LIME DOWN SOLAR PROJECT

DEADLINE 6 TRANSPORT SUBMISSION STOP LIME DOWN

September 2026

Drawing file: published-documents / EN010168-002736-6.2 ES Volume 2 Figure 13-11 Construction Access Locations Solar PV Sites (Rev 3).pdf

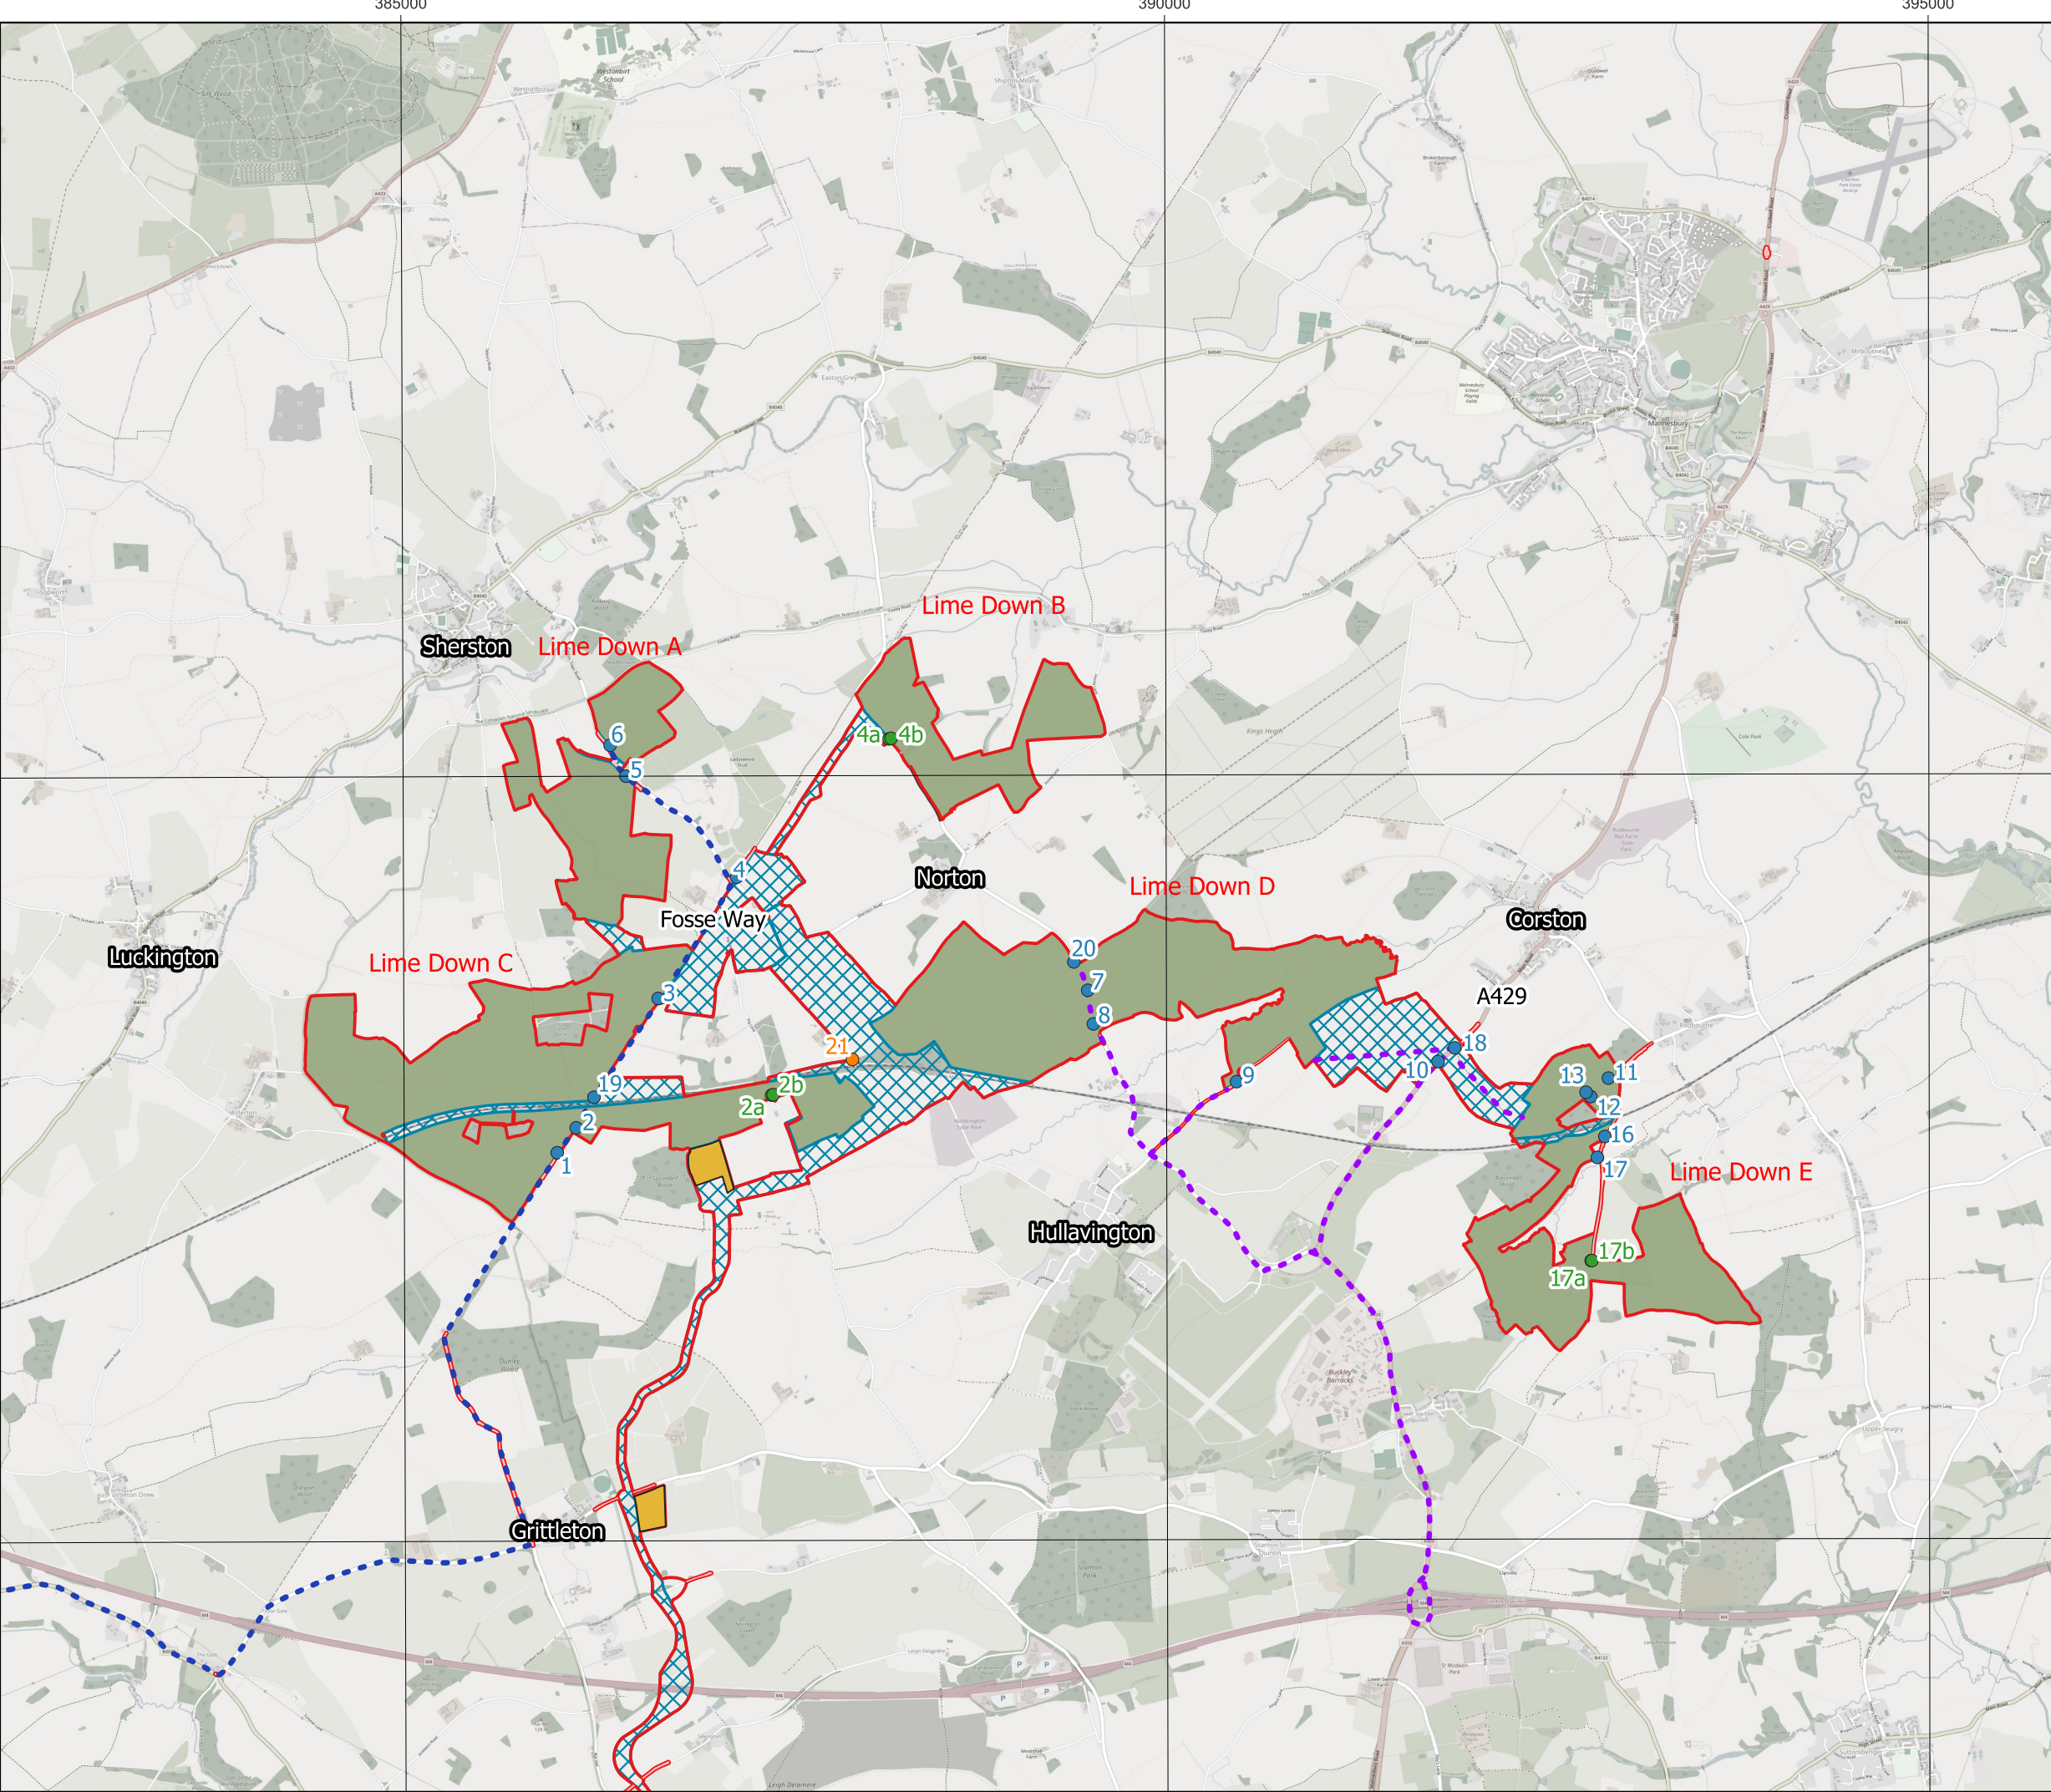
2.1.1. The location of access 12 that serves Lime Down E 132kV substation has been moved to the south-west and is now opposite access 13. Whereas the previous access made use of an existing field access, the proposed access is entirely new. It appears that the rationale for this is to allow AIL vehicles to avoid travelling along the lane. The swept path drawing for access 13 (PL13D) shows an AIL vehicle crossing the lane between access 13 (north-west of the lane) and access 12 (south-east of the lane). It is not clear how the AIL vehicle accesses the internal track network north of the lane to allow this straight across movement. Mr. Bamber considers that this should be explained.

2.2.1. The changes to access 12 described above in relation to the TA are carried over into the CTMP.
